## **RE: 780 Wallgrove Road, Horsley Park SSD-9601 Modification – Response to Submission - Transport Statement**

Reference has been made to the Department of Planning, Industry and Environment (DPIE) response sent on 24 January 2022 in relation to Modification (MOD 1) for SSD-9601 at 780 Wallgrove Road, Horsley Park (the Site). In this regard, Brickworks Land & Development have commissioned Ason Group to prepare a response to the DPIE comments. Details of our assessment are as follows.

**TABLE 1: RESPONSE TO DPIE'S COMMENTS**

**10 DRIVEWAY LONGITUDINAL SECTION**  
 SCALE 1:100 HORI.  
 1:100 VERT.

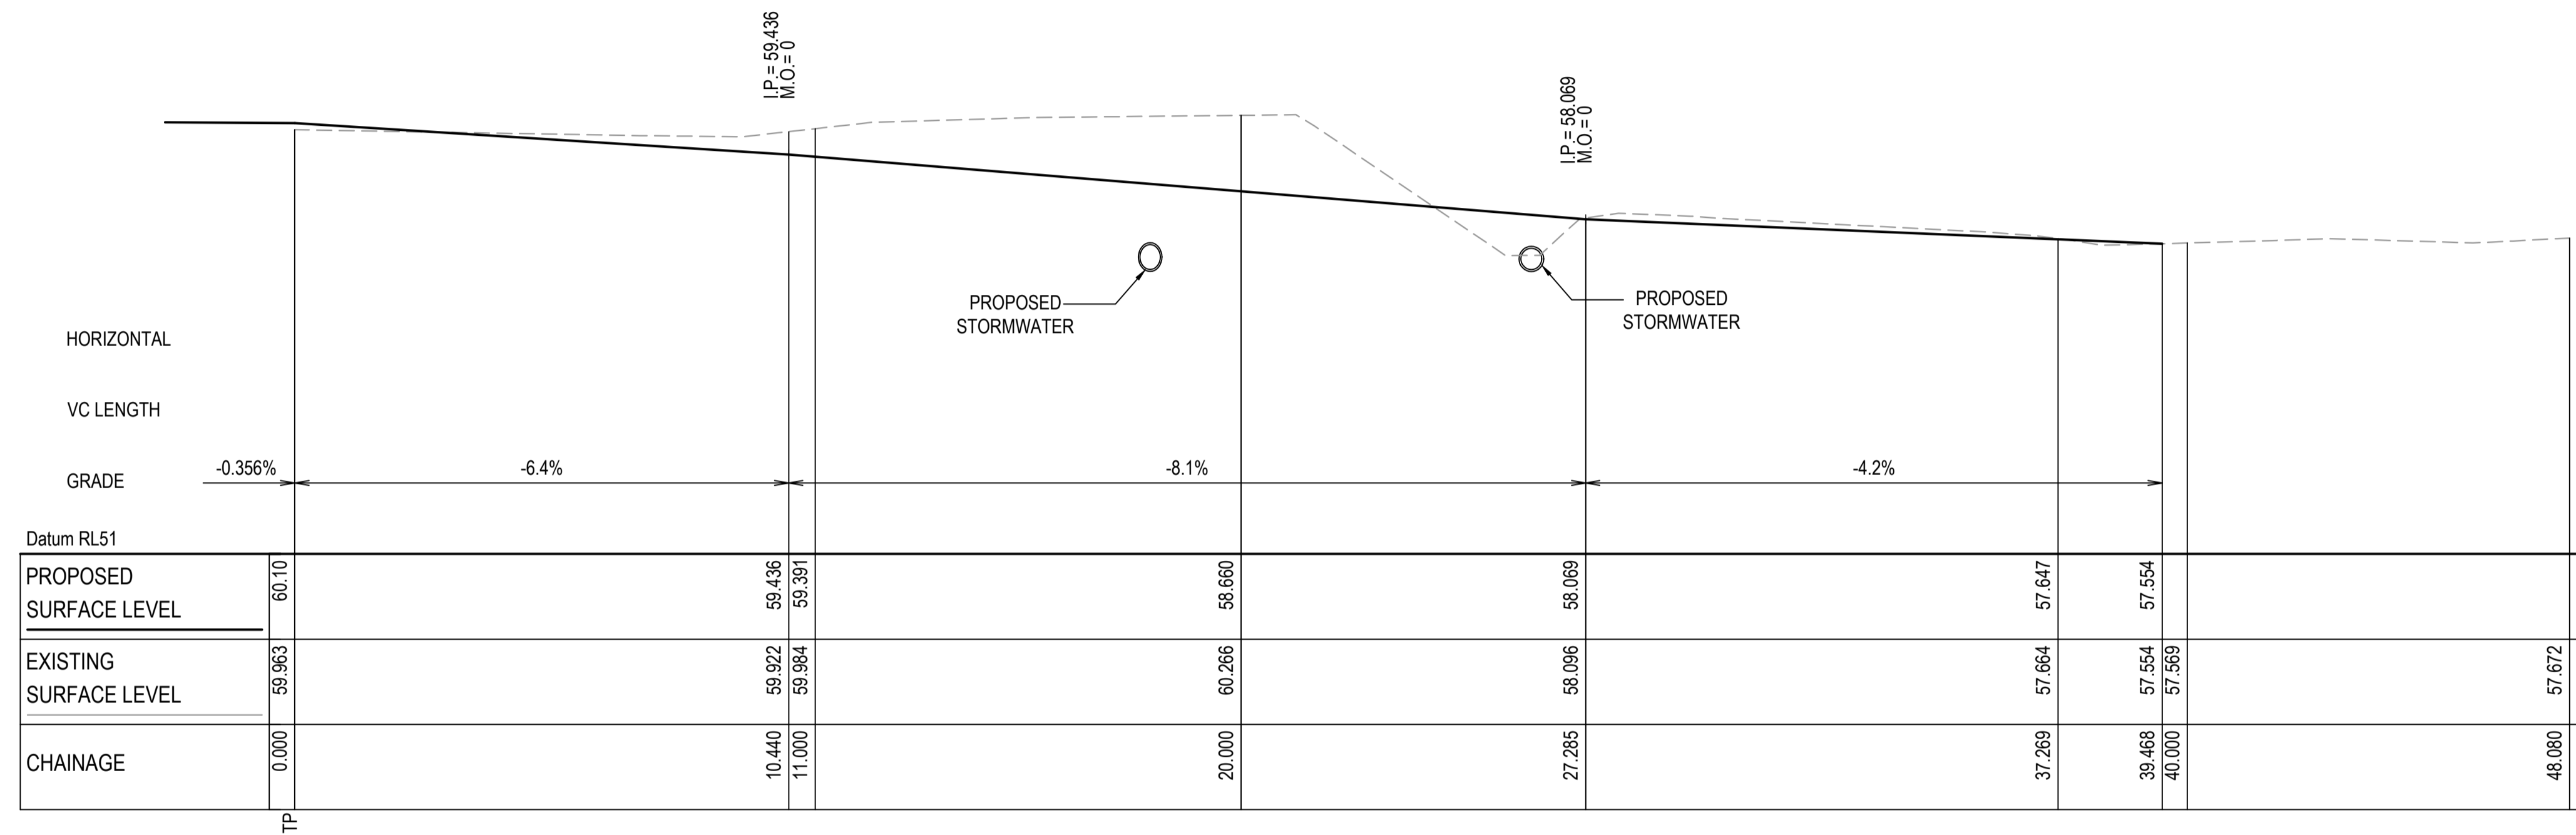
8	Longitudinal section of the ramp (adjacent to the car park) indicating grades and levels to accommodate heavy vehicles shall be submitted to Council for assessment.	Please refer to the most recent design for the proposed driveway provided by AT&L. The section has been designed to be in full compliance with the requirements stated in AS2890.2:2018 for 12.5m HRVs.

VEHICLES POSITIONED IN WAITING BAY  
1 : 250

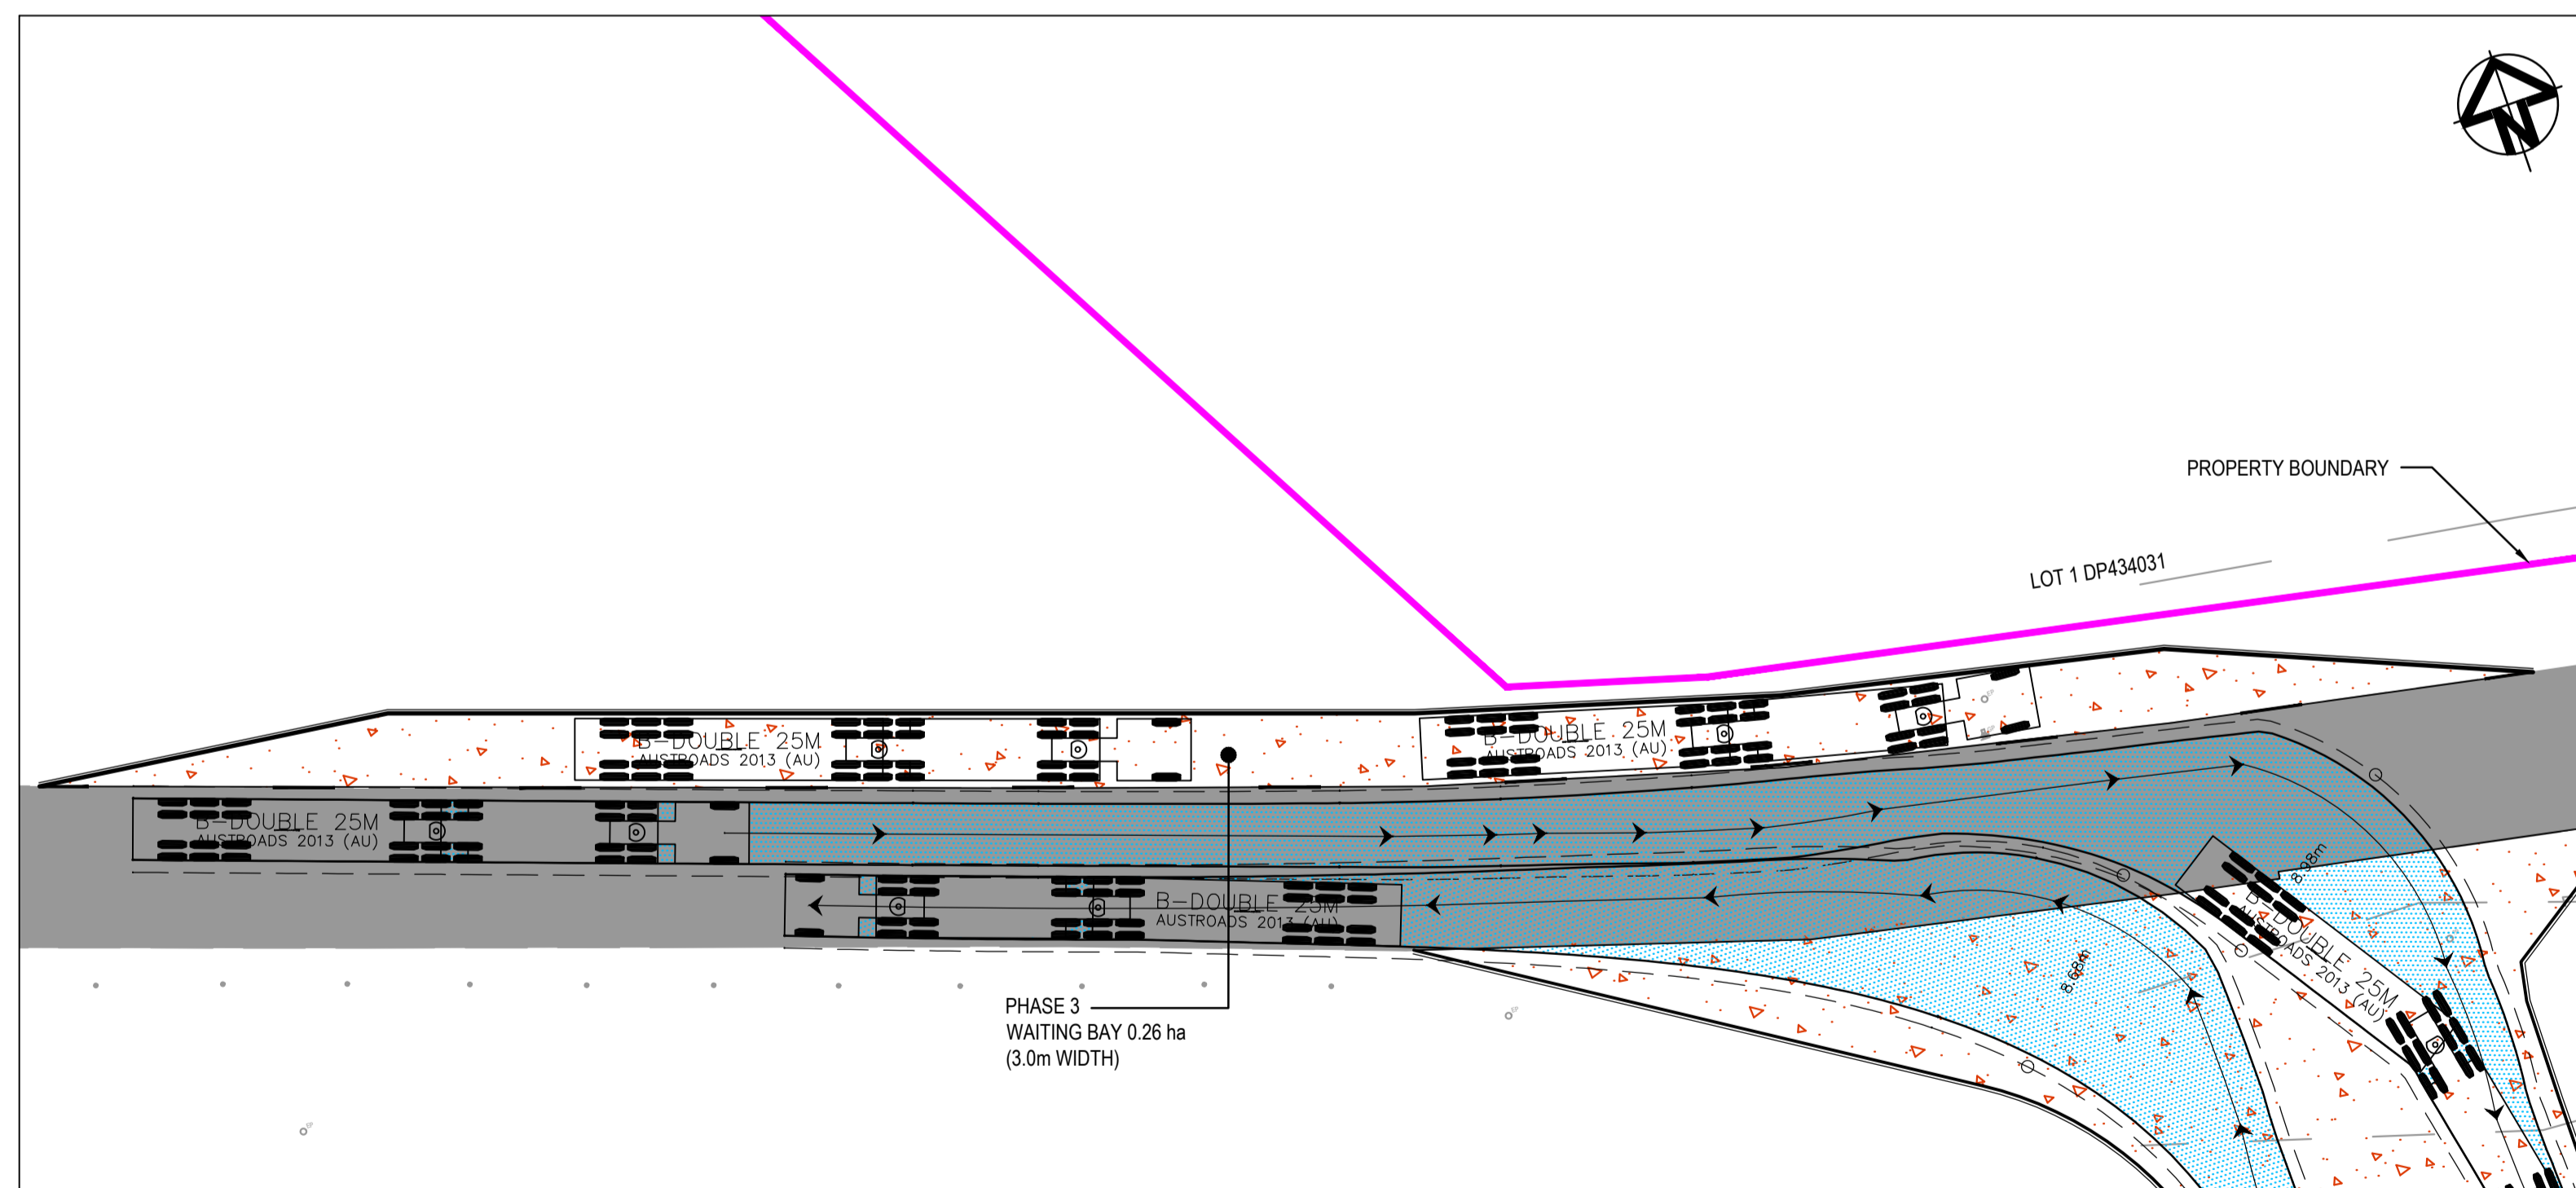
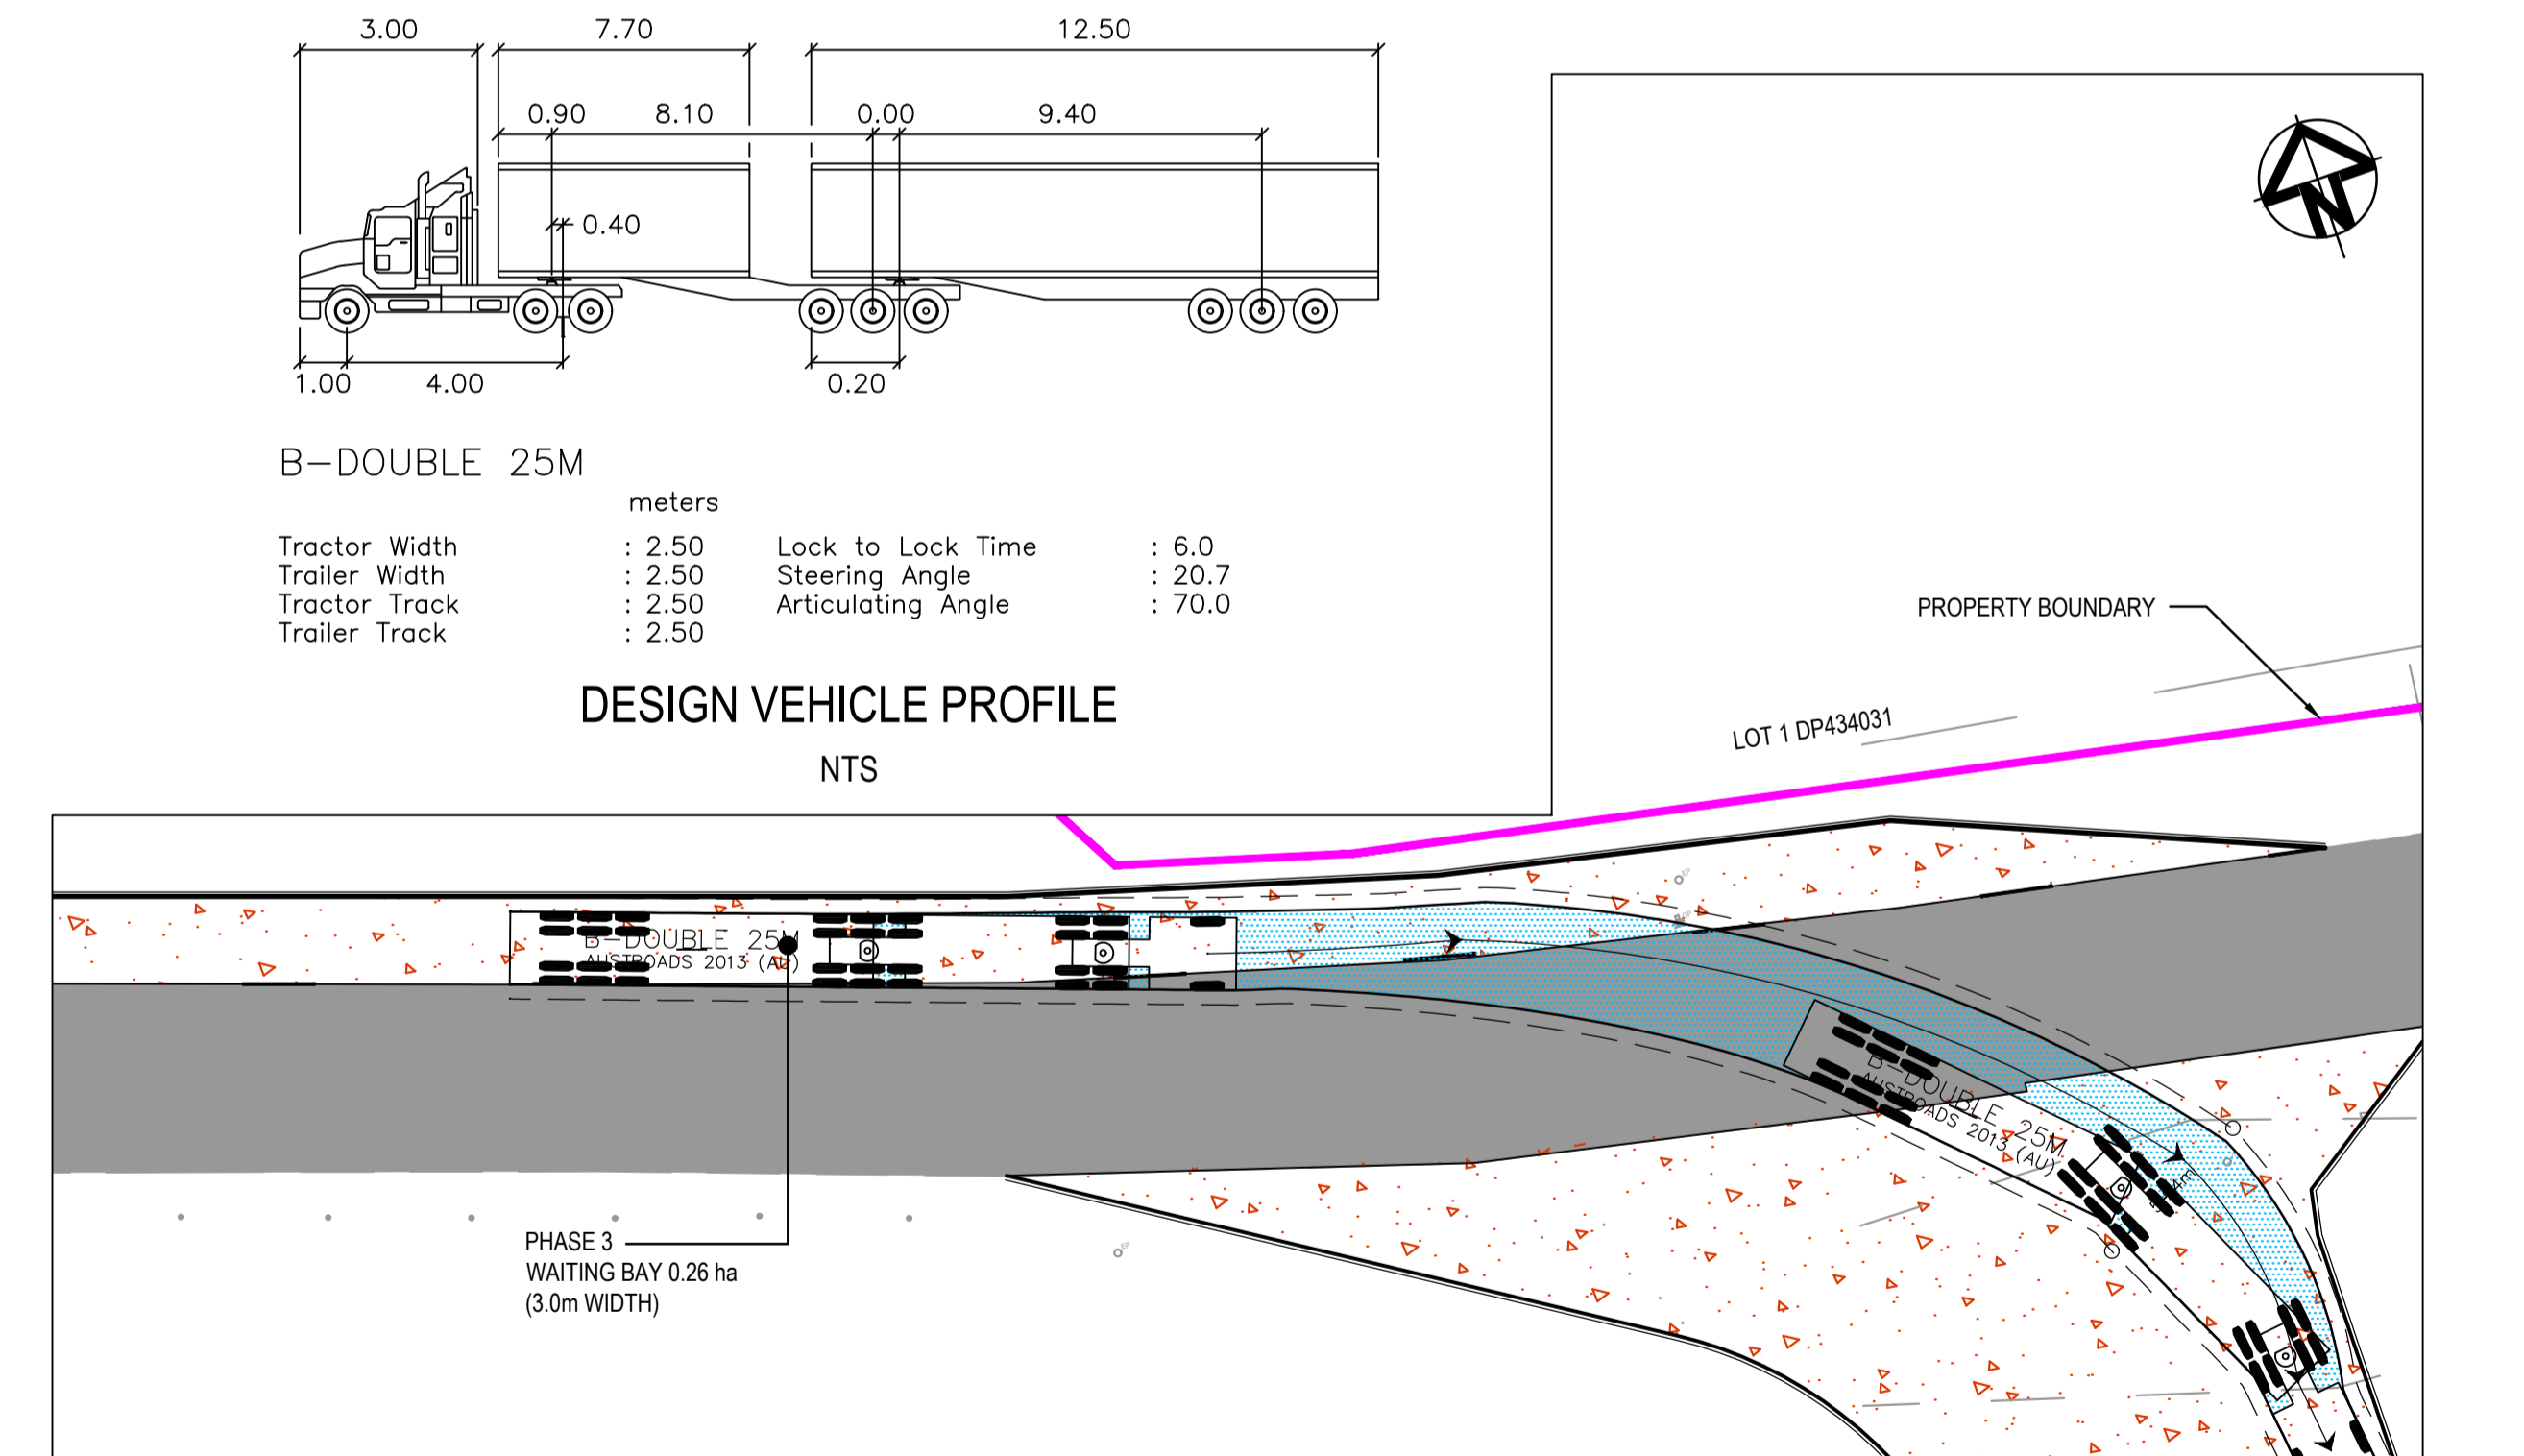
appropriate signage to facilitate safe traffic movements.
6	Clarification regarding the waiting bay proposed adjacent to the entry driveway of the development site	The waiting bay adjacent to the driveway is proposed to allow vehicles to queue outside the site entry in scenarios where there may be traffic congestion at the driveway, which would prevent right turn movements into the Site. The waiting bay will allow trucks to queue without blocking the through movements on Access Road and is therefore beneficial to the operation of Access Road.
7	The proposed hardstand areas to cater for various types of heavy vehicles within the site shall be dimensioned and be reflected on the plans	Appendix A provides swept path analysis of expected heavy vehicle movements within the proposed hardstand location, this includes dimensions of the hardstand area and the respective proposed stockpile locations. Please refer to the most recent architectural plans from SBA Architects.
